Application Ref:	3/2025/0467			 Ribble Valley Borough Council www.ribblevalley.gov.uk
Date Inspected:	N/A	Site Notice:	N/A	
Officer:	EP			
DELEGATED ITEM FILE REPORT:				APPROVAL

Development Description:	Lawful Development Certificate for construction of a single storey side and rear extension.
Site Address/Location:	10 Mearley Syke, Clitheroe BB7 1JG.

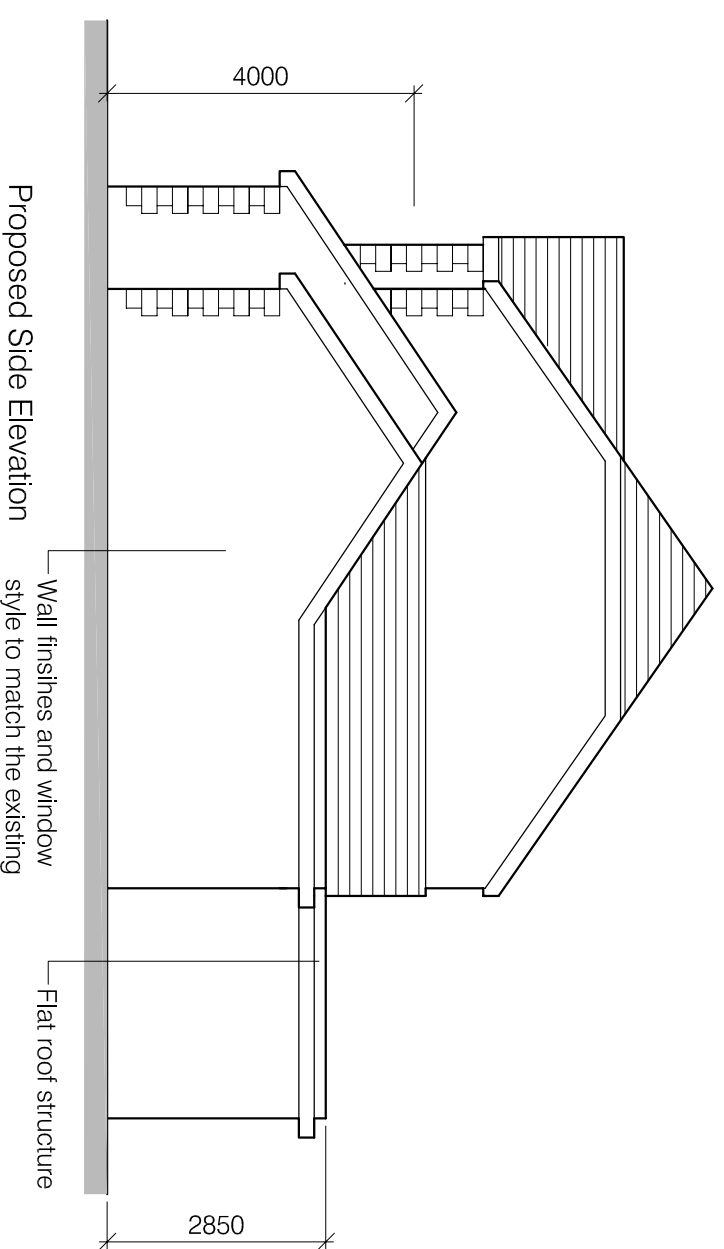
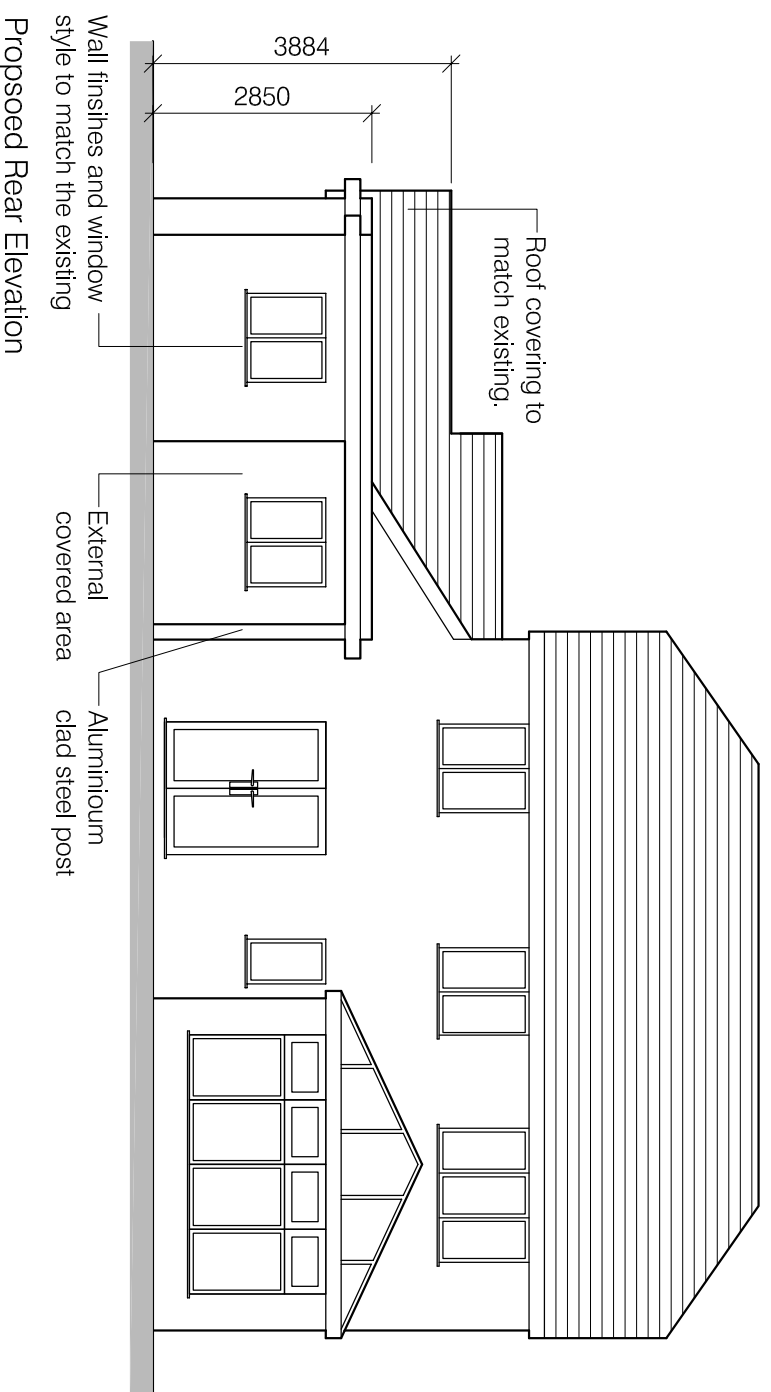
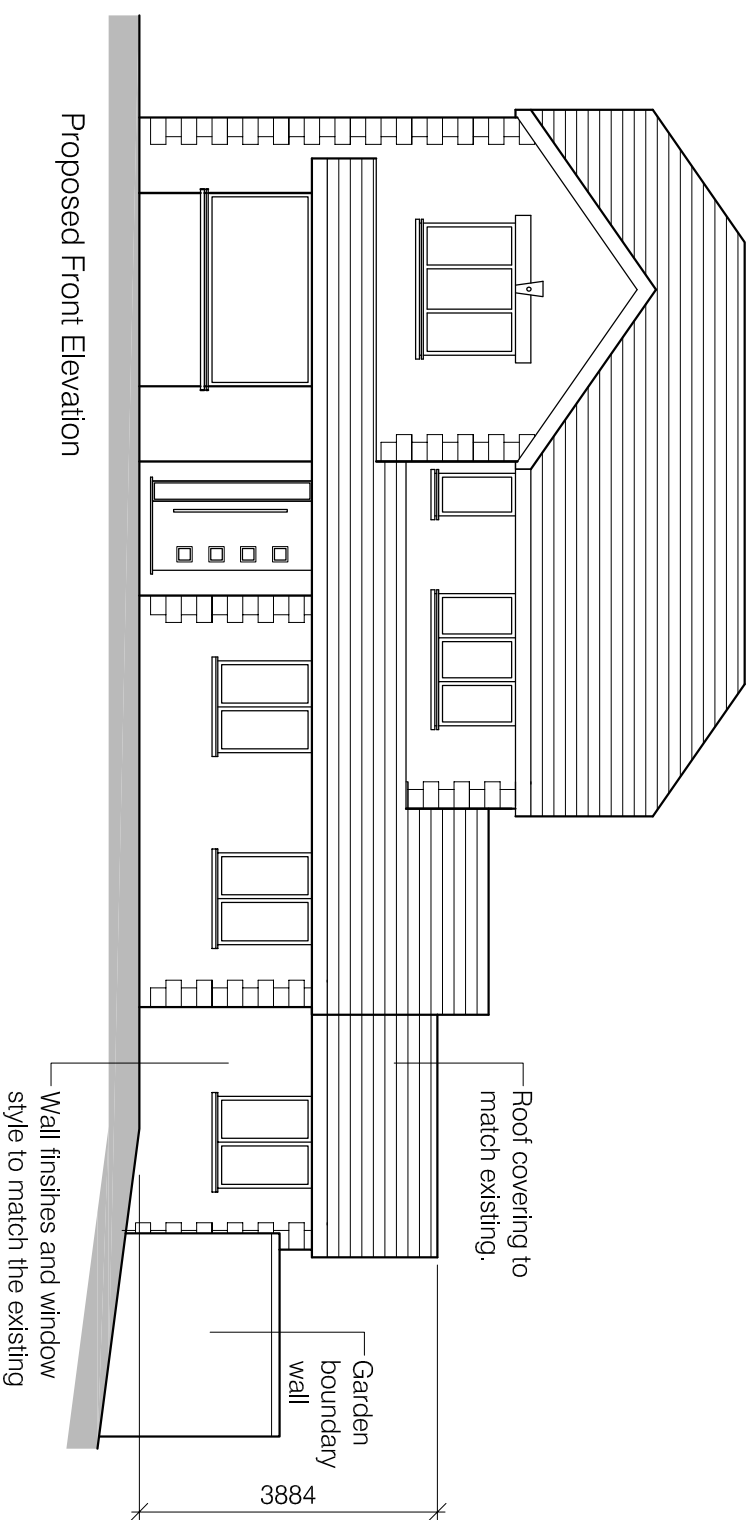
The proposed single storey extension will extend beyond the rear elevation of the dwelling by 3m and will measure 3.88m in height.

The proposed single storey extension will not exceed 3 metres in height to the eaves.

The proposed single storey extension would adjoin an existing rear infill extension, the total width of the existing extension and the proposed extension would not exceed half the width of the existing dwelling. The extension does not measure more than 4m in height and is single storey in nature.
